Application no: H23-1082-14

Description: Residential development for 10 units on redundant farmyard (re-submission of H23-1026-14)

Amendment: Relocate protected tree, realign access road, reduce
piping of dyke + change refuse collection system

ACKNOWLEDGEMENT OF AMENDMENT

Drawing No. 10/246/PA/007

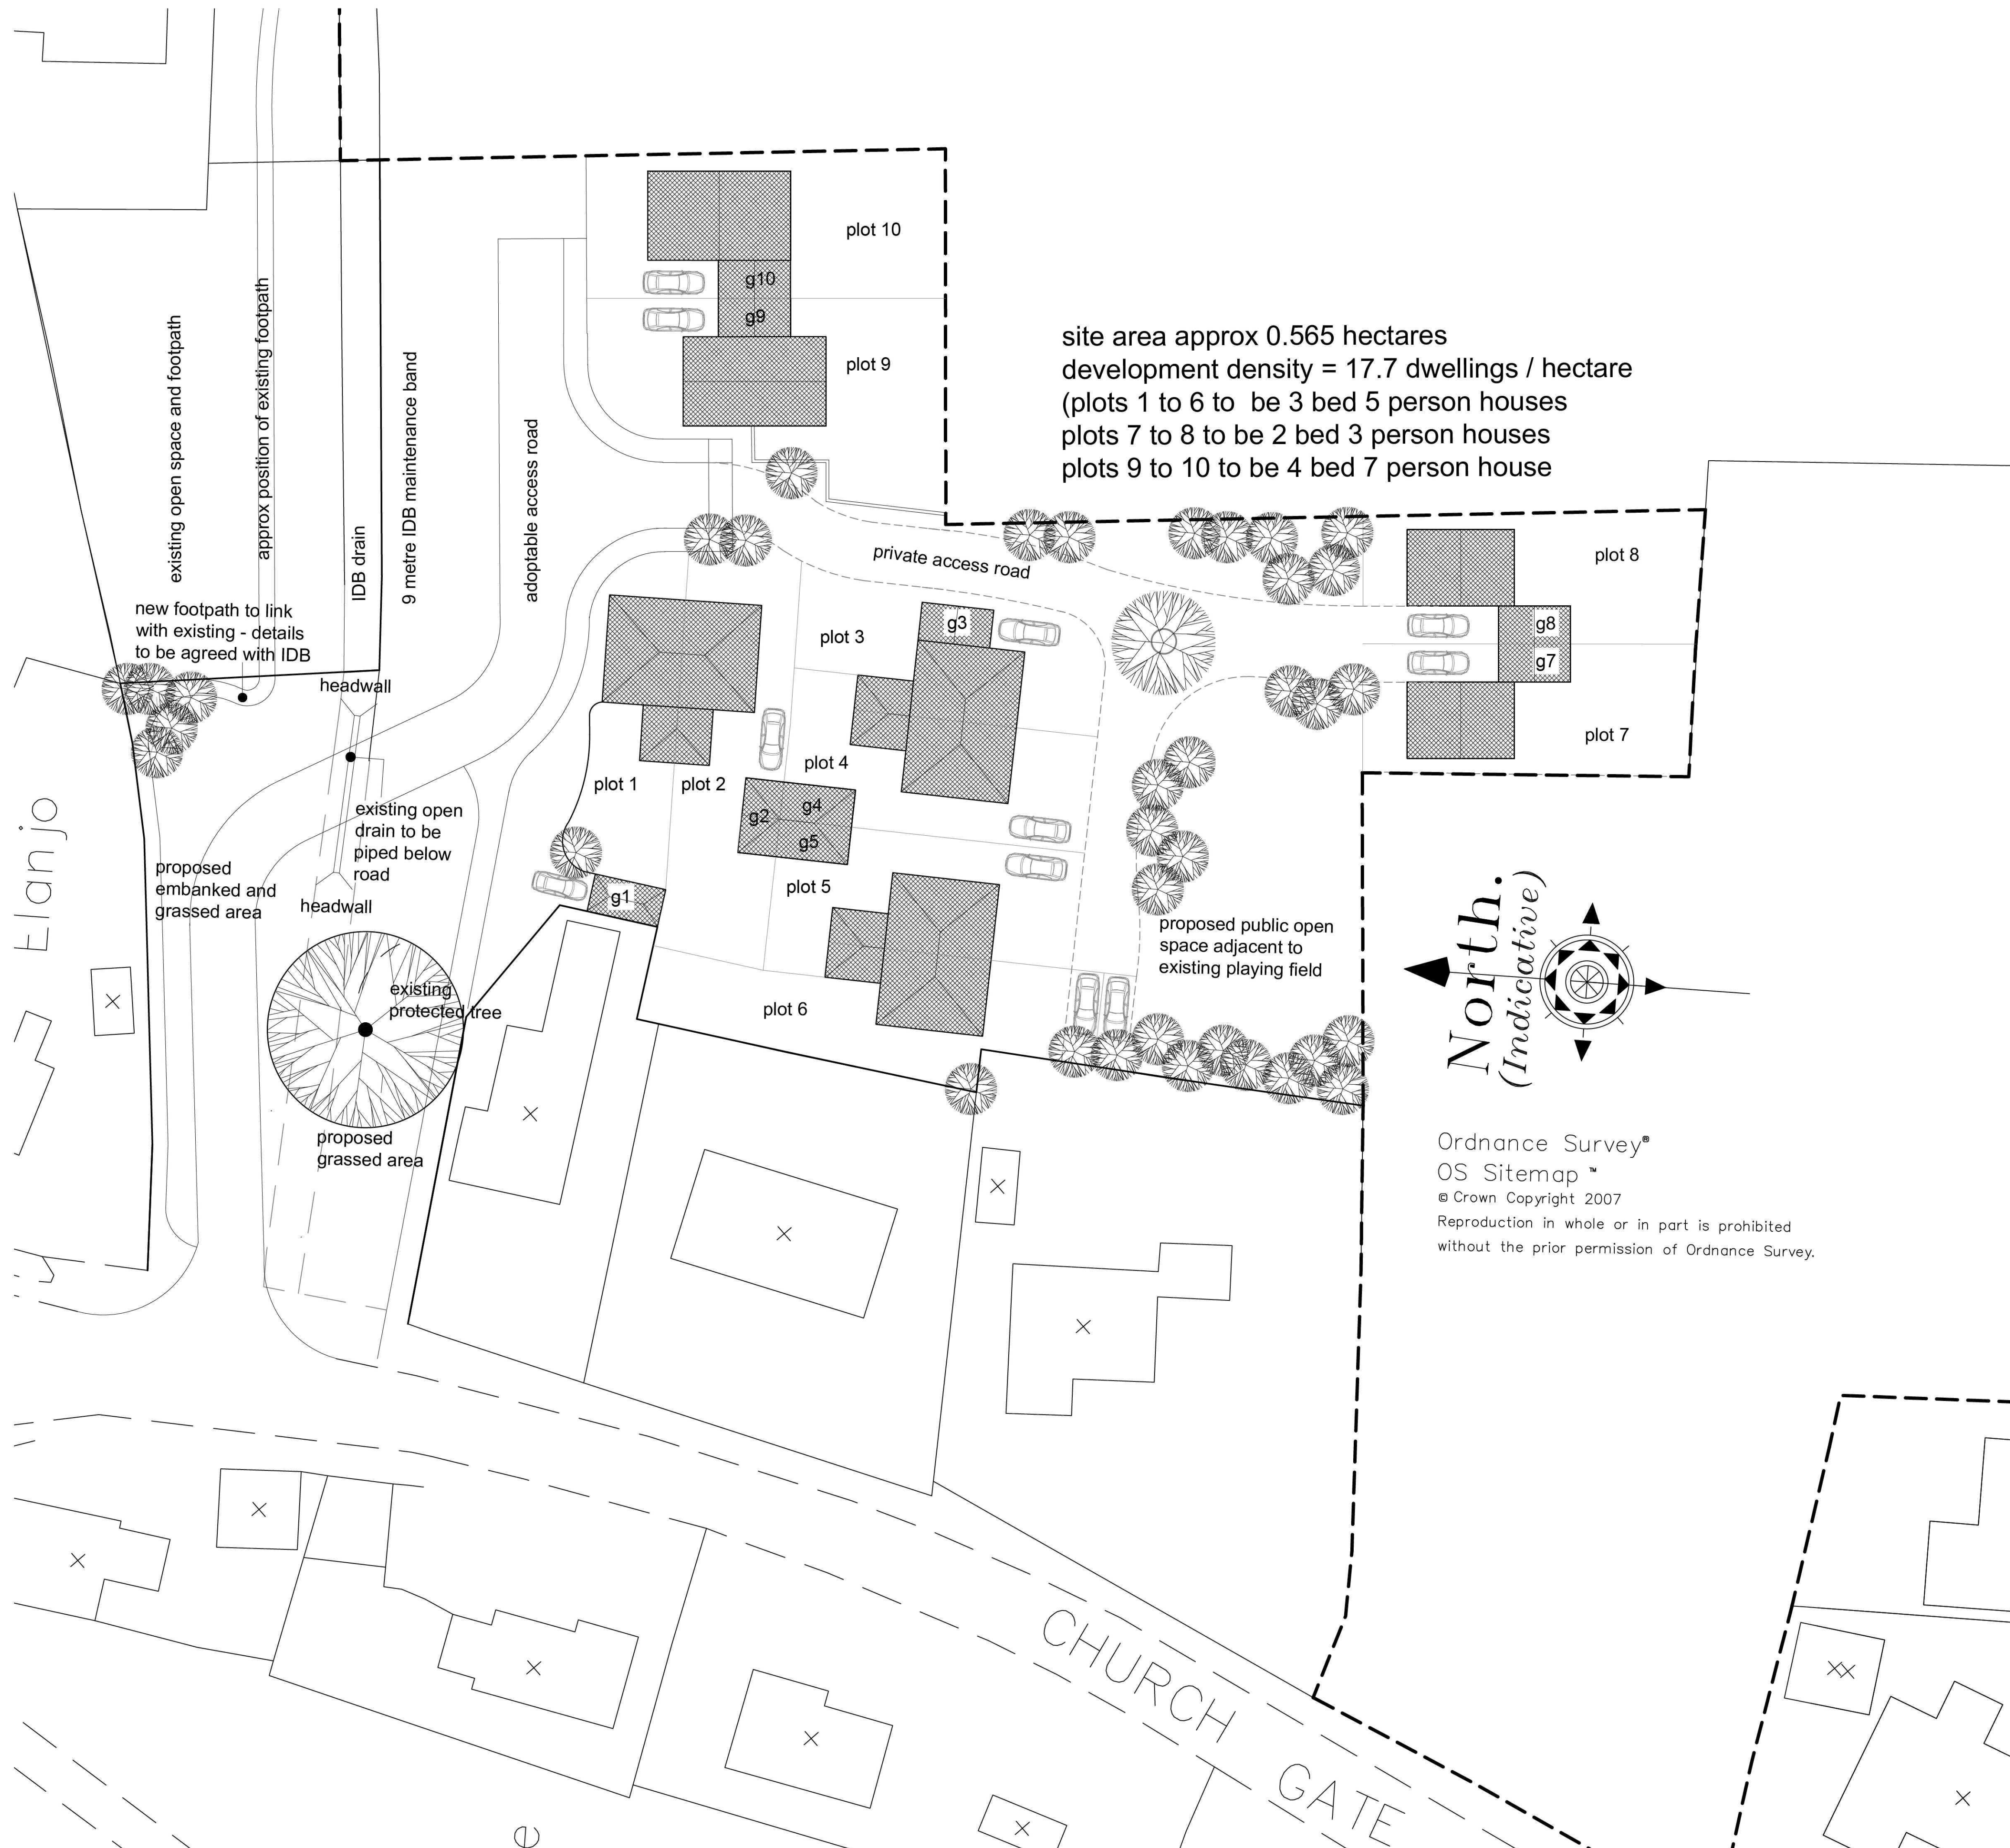
Relocation of protected tree and realignment of access road, reduced piping of dyke and change to refuse collection system (dwg. no. 10/246/PA/007 and Design and Access Statement)
